Regulatory, Planning and Assessment.MBisson/GMansfield
Reference: PB2020/01440 & PB2020/01747
Phone: 4974 2000

20 March 2020

UNIVERSITY OF NEWCASTLE HONEYSUCKLE CITY CAMPUS CONCEPT PLAN (SSD-9262)

I refer to the Department's electronic notification of 31 January 2020 advising the University of Newcastle has submitted a revised Response to Submissions ('RtS') (2) and requesting City of Newcastle's ('CN') advice.

Figure 6 Overshadowing of amended building envelopes

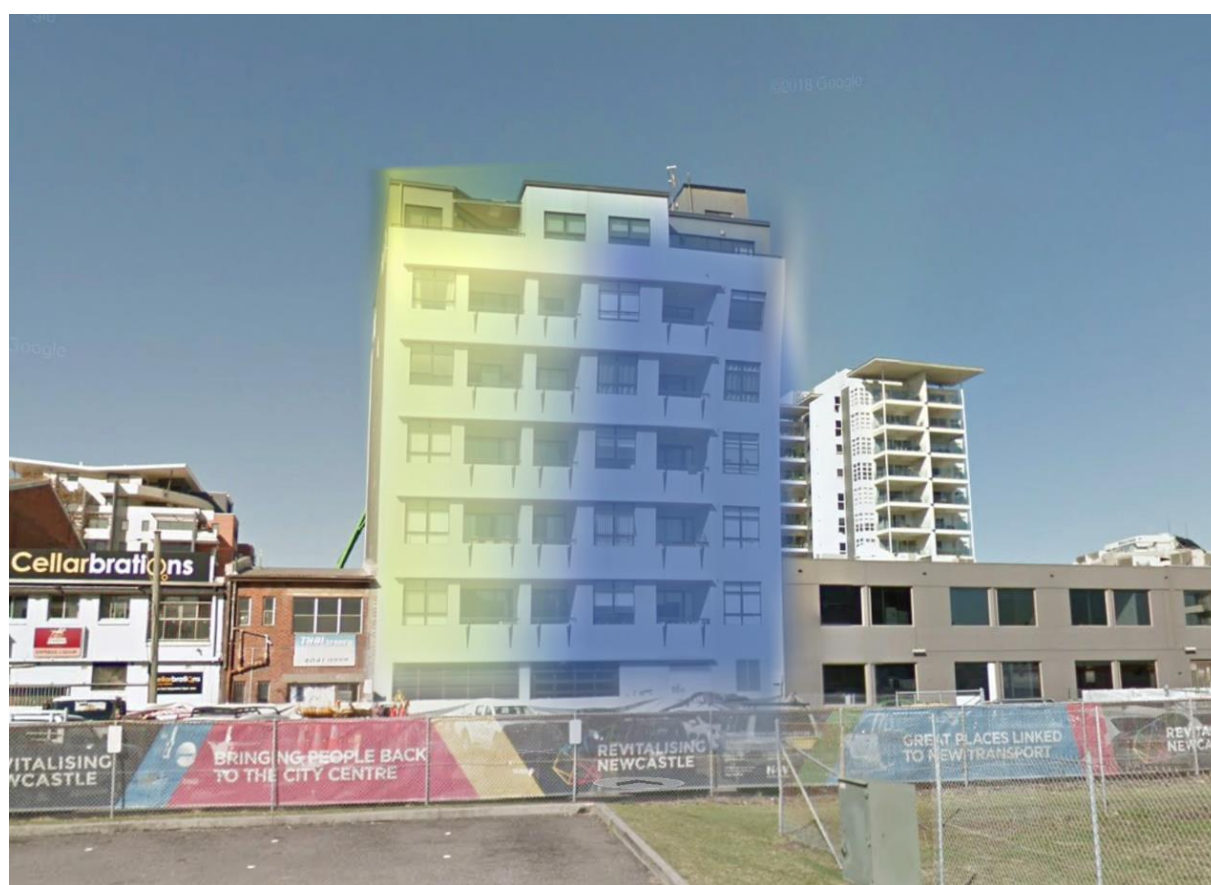
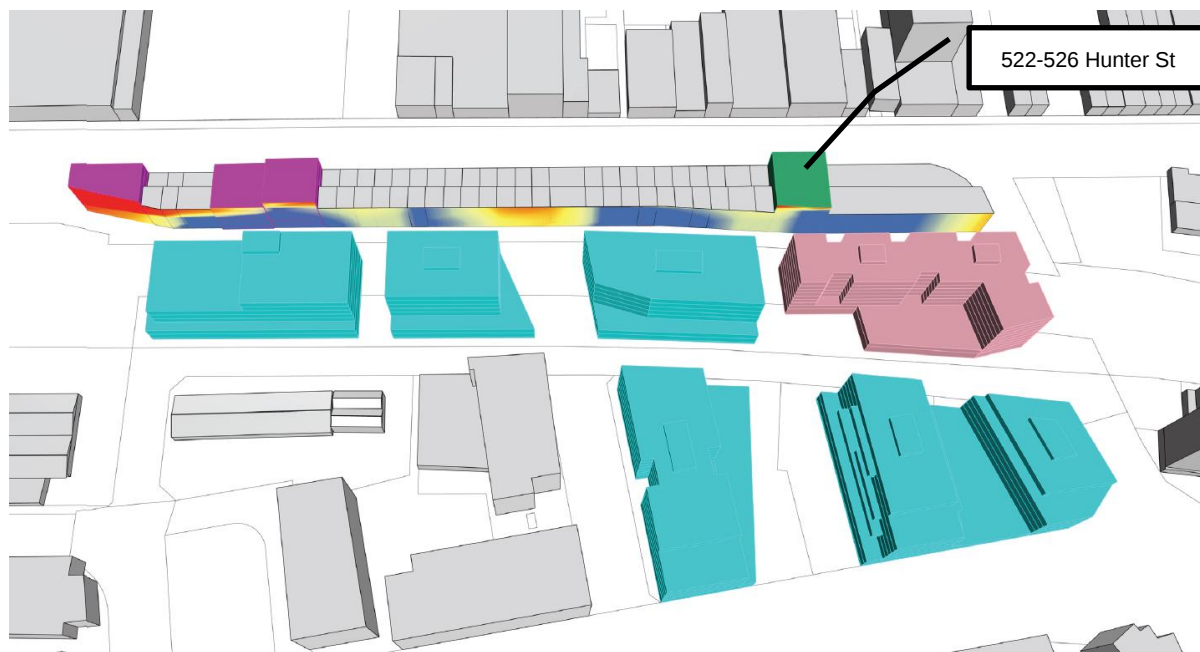
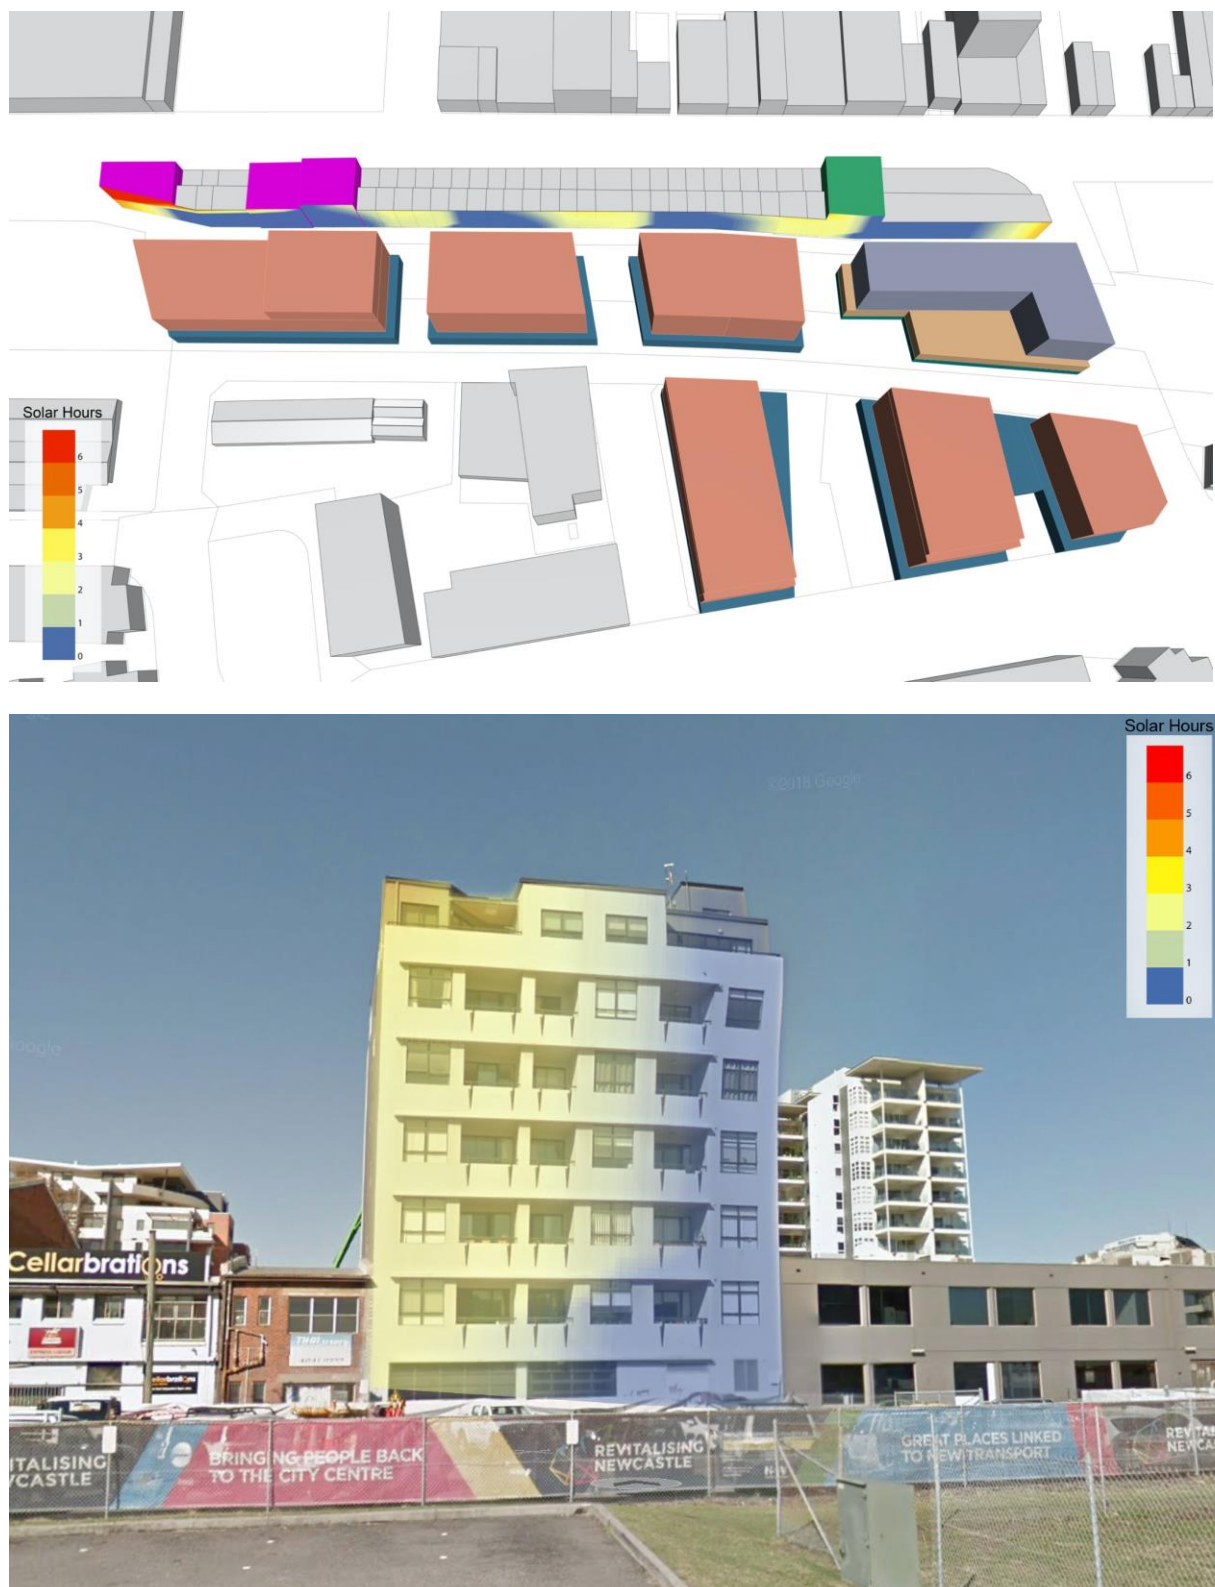
In the RtS (2) (Dec 2019) it is stated that *'the majority of the northern façade will now receive at least 2 hours solar access, mid-winter'*. The supplementary information (Jan 20) to the RtS (2) provides further overshadowing analysis of the likely impacts on the above RFB, as well as three other properties containing residential uses. In respect of the RFB, Table 1 states that eleven of the twelve dwellings facing Civic Lane will receive partial solar access to their balconies. This statement does not appear to be collaborated by the image in Figure 3 which show that six dwellings will receive no solar access to their balconies.

In respect of properties Nos 510 Hunter Street and 474 Hunter Street it is stated that the dwellings will be *'partially overshadowed'*, no attempt has been made to quantify these impacts and Figure 1 because of its scale provides no assistance in this regard. It is argued that these impacts are based on *'worst-case building envelopes and it is likely that solar access will be improved to this area with the detailed design.'* It is not explained how this will be achieved.

It is further argued that as the analysis is based on mid-winter solar access, which is a worst-case, solar access to the dwelling will *'quickly improve throughout the year'*. This may be the case, however the performance criteria for considering overshadowing of neighbouring properties is mid-winter when access to solar access is most appreciated. Table 1 also concedes that the 'shop top' dwelling on No 502 Hunter Street will be overshadowed. Also, it is noted that the analysis does not include the 'shop top housing' and approved boarding house on property No 480 Hunter Street. (Refer to DA2016/01433 & DA2019/01164).

In considering this aspect of the development, it should be borne in mind that the residents of the above properties currently enjoy unimpeded solar access (and views) all year round. It is apparent that for some residents solar access to their homes in mid-winter will be significantly reduced or eliminated entirely by the proposal. Further, it has not been demonstrated how such impacts could be addressed at the detail design stage.

As stated in CN's previous advice, while the likely positive contribution of the development to the revitalisation of the City Centre is recognized, the development should not unreasonably impact on the existing residential development facing Civic Lane. Given the above circumstances it is recommended the applicant be required to give further consideration to this issue.
